**CITY OF PORTLAND, MAINE  
DEVELOPMENT REVIEW APPLICATION  
PLANNING DEPARTMENT PROCESSING FORM  
DRC Copy**

**2004-0022**

**95 Cove Side Dr.**

**Approval Conditions of DRC**

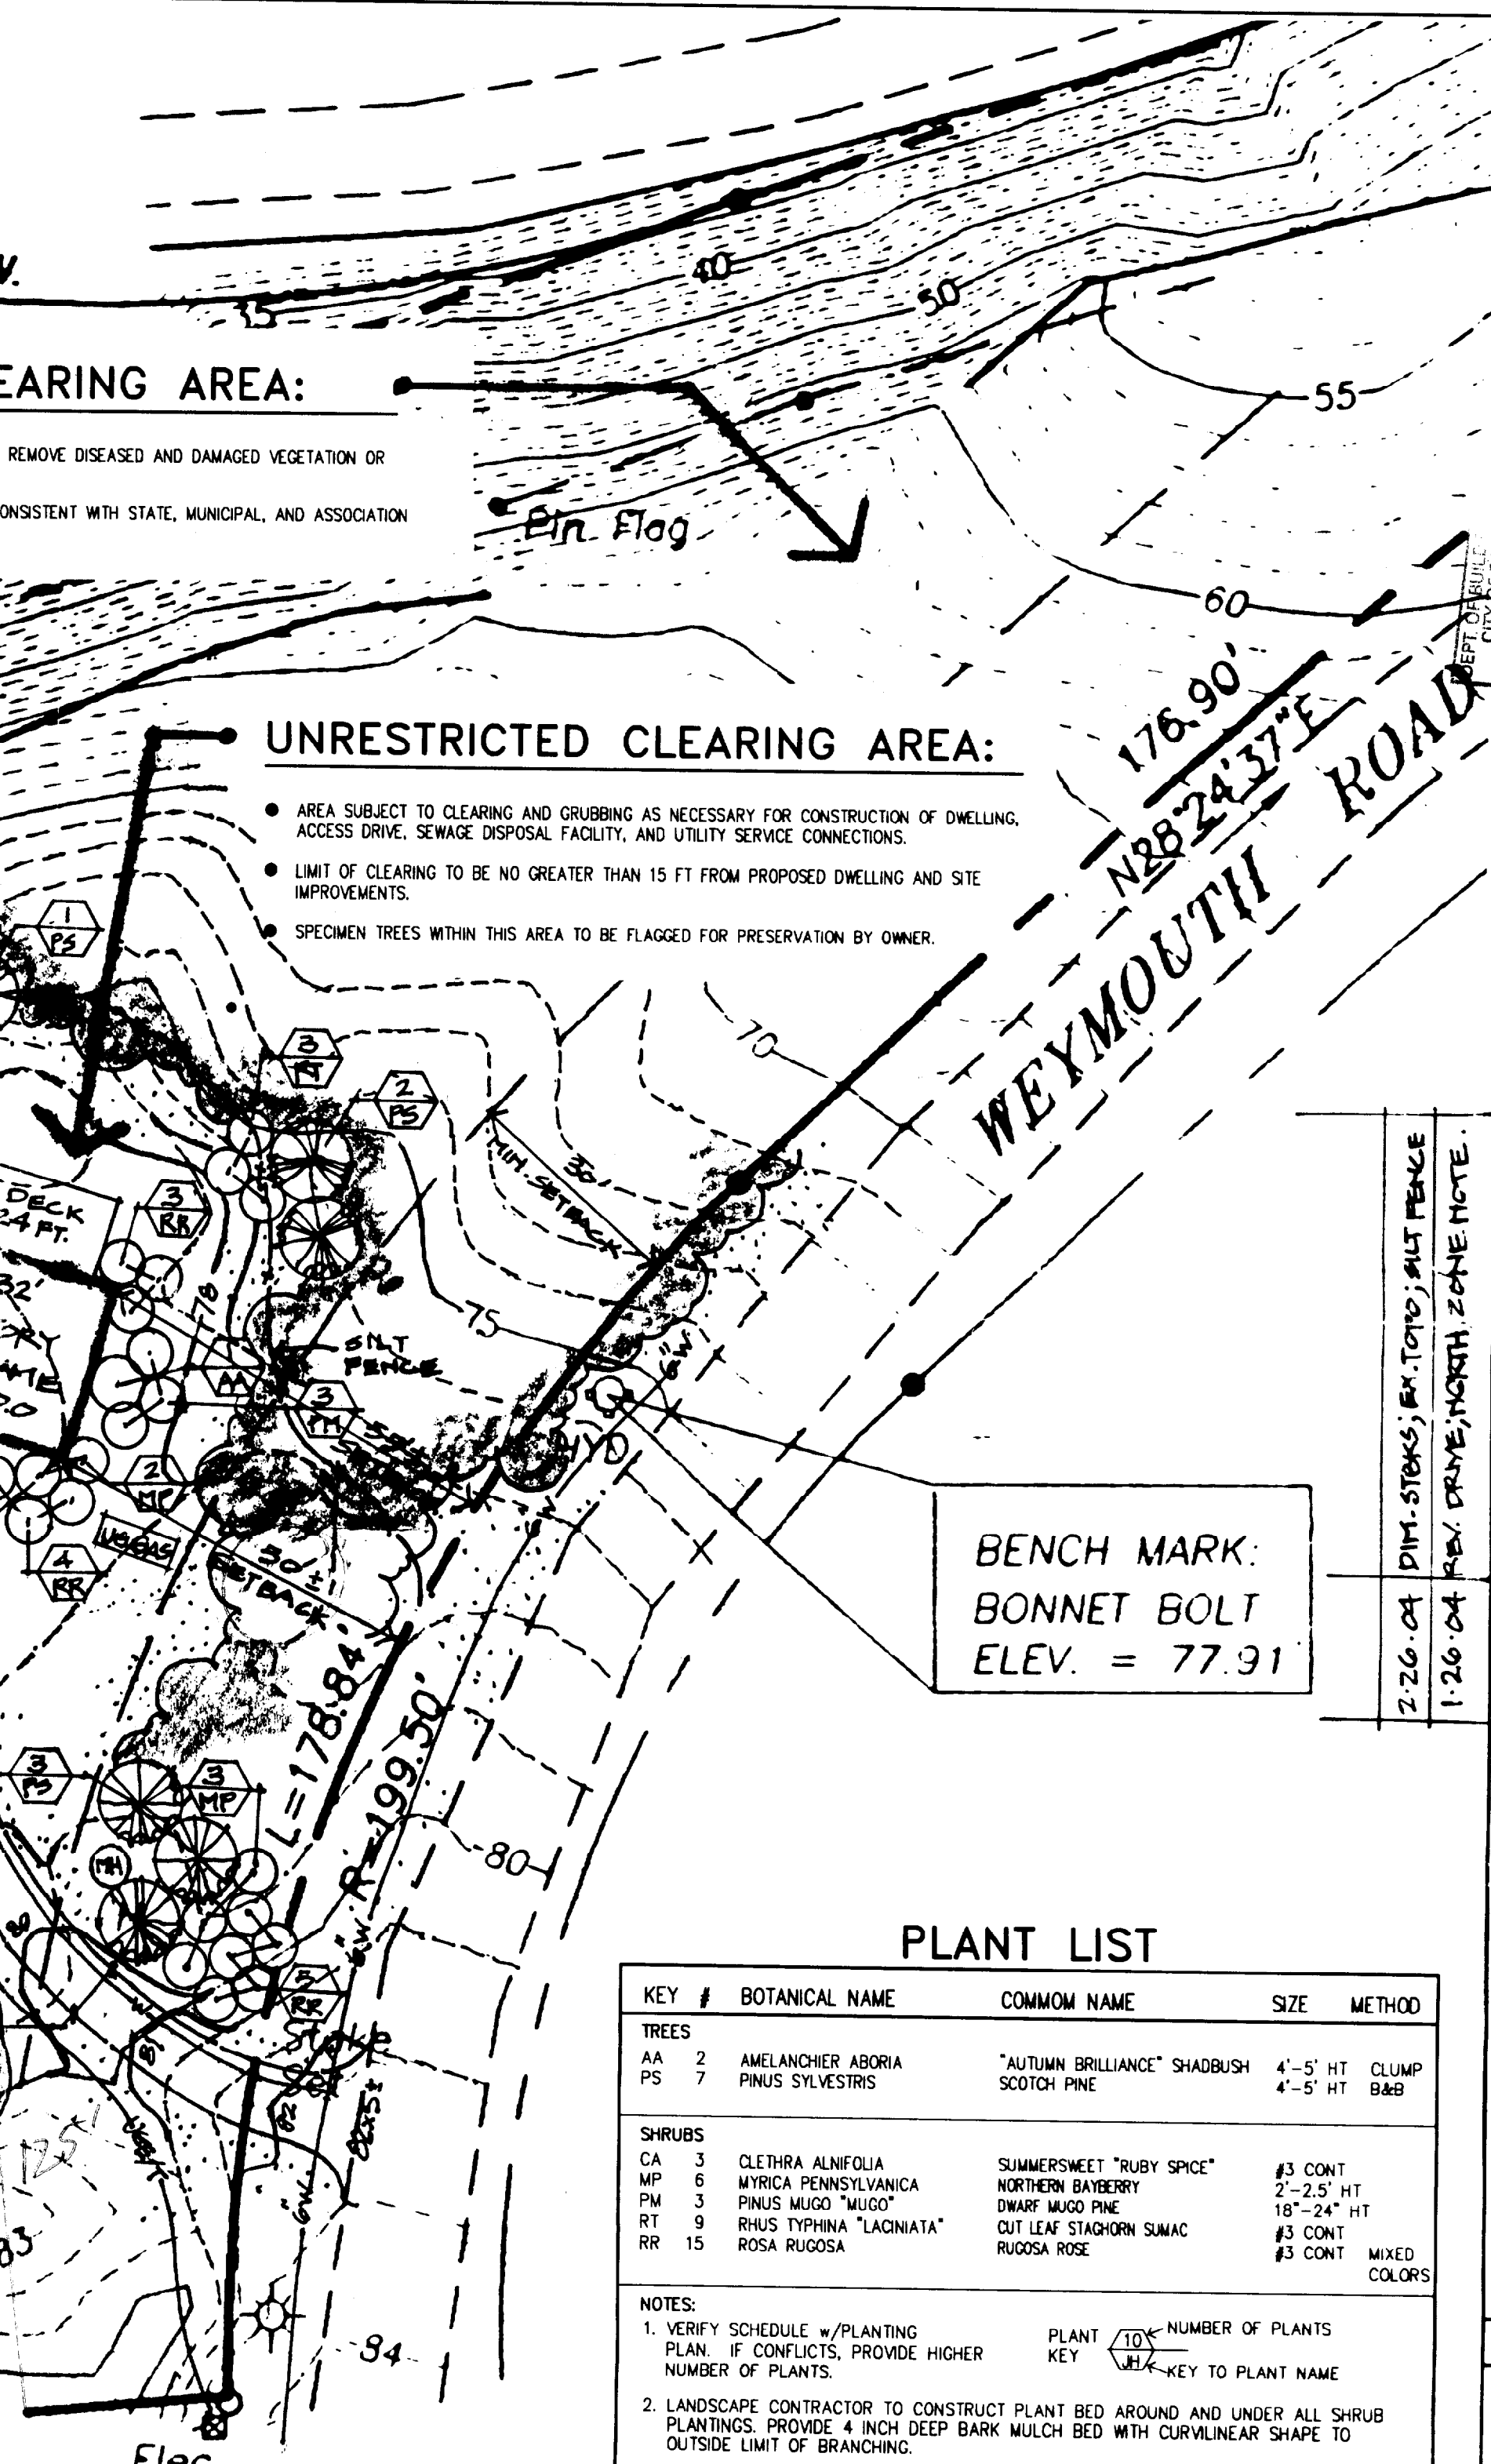
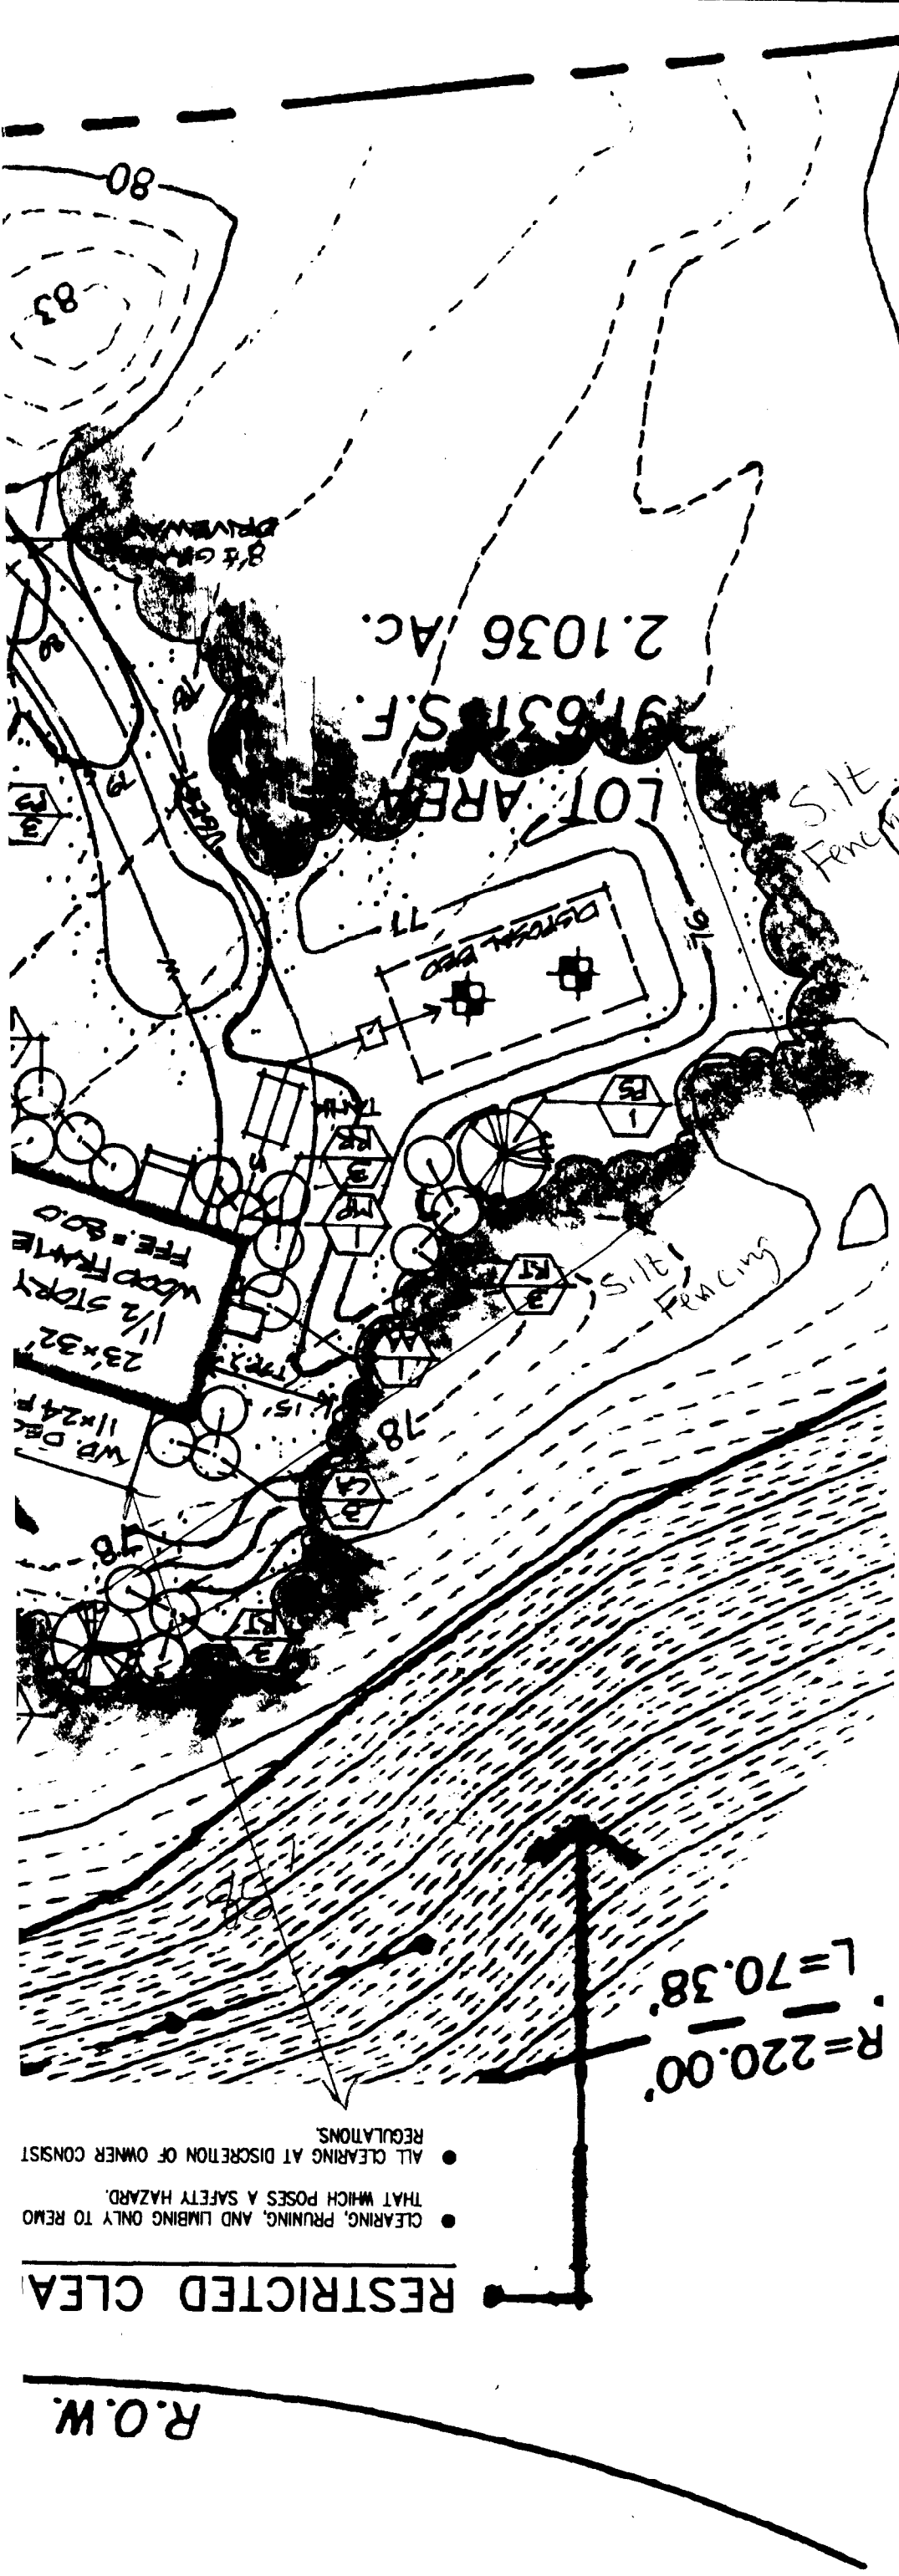
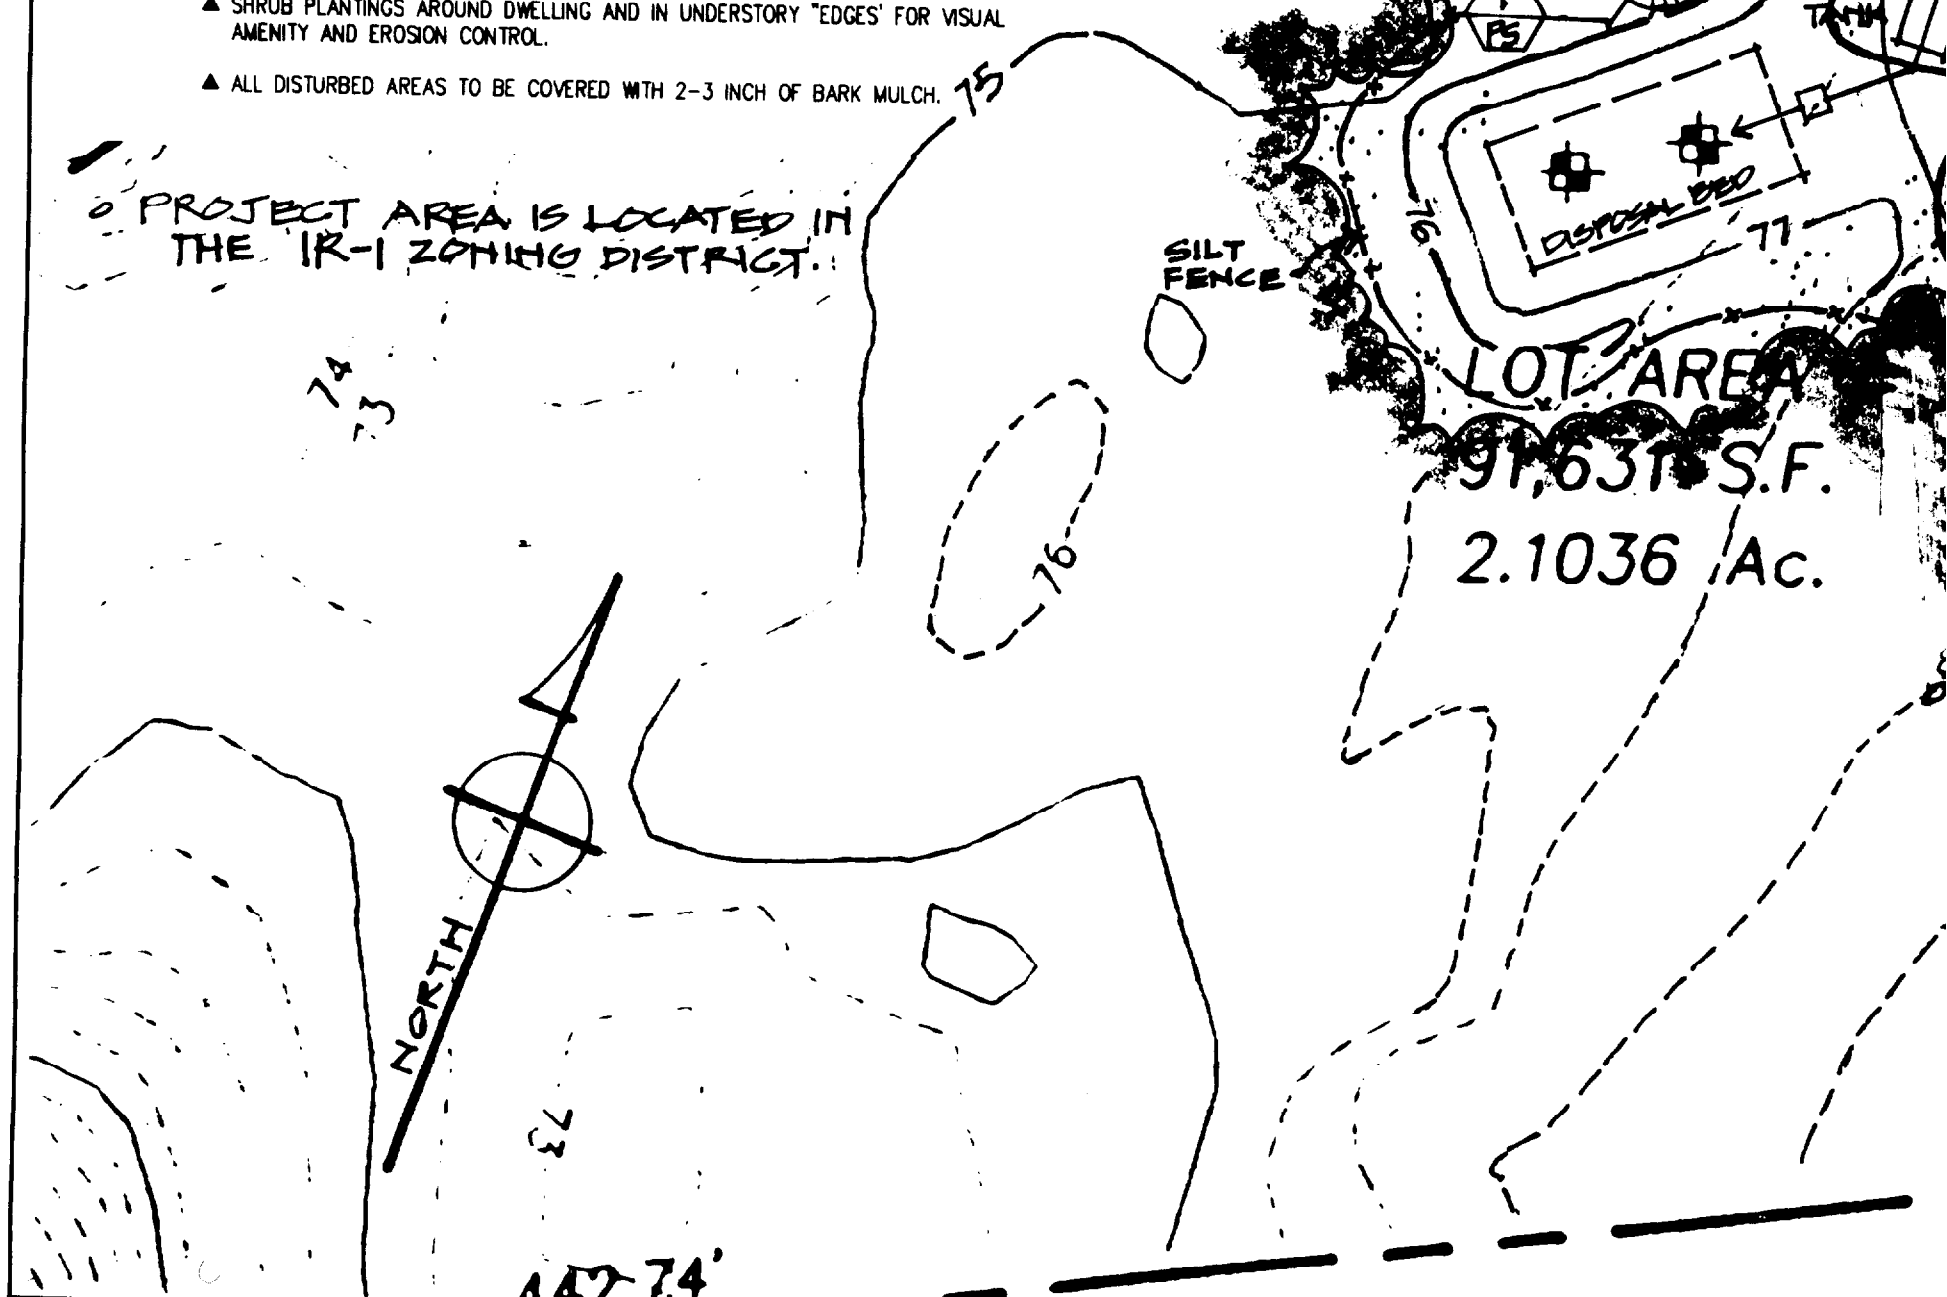
- 1 Silt Fence installation shall remain outside of the restrictive clearing area.
- 2 Your new street address is now #36 Weymouth Road, the number must be displayed on the street frontage of your house prior to issuance of a Certificate of Occupancy.
- 3 A street opening permit(s) is required for your site. Please contact Carol Merritt ay 874-8300, ext. 8822. (Only excavators licensed by the City of Portland are eligible.)
- 4 The Development Review Coordinator reserves the right to require additional lot grading or other drainage improvements as necessary due to field conditions.
- 5 All Site Work will conform to the City of Portland ordinance on Shoreland Regulations (Division 26).
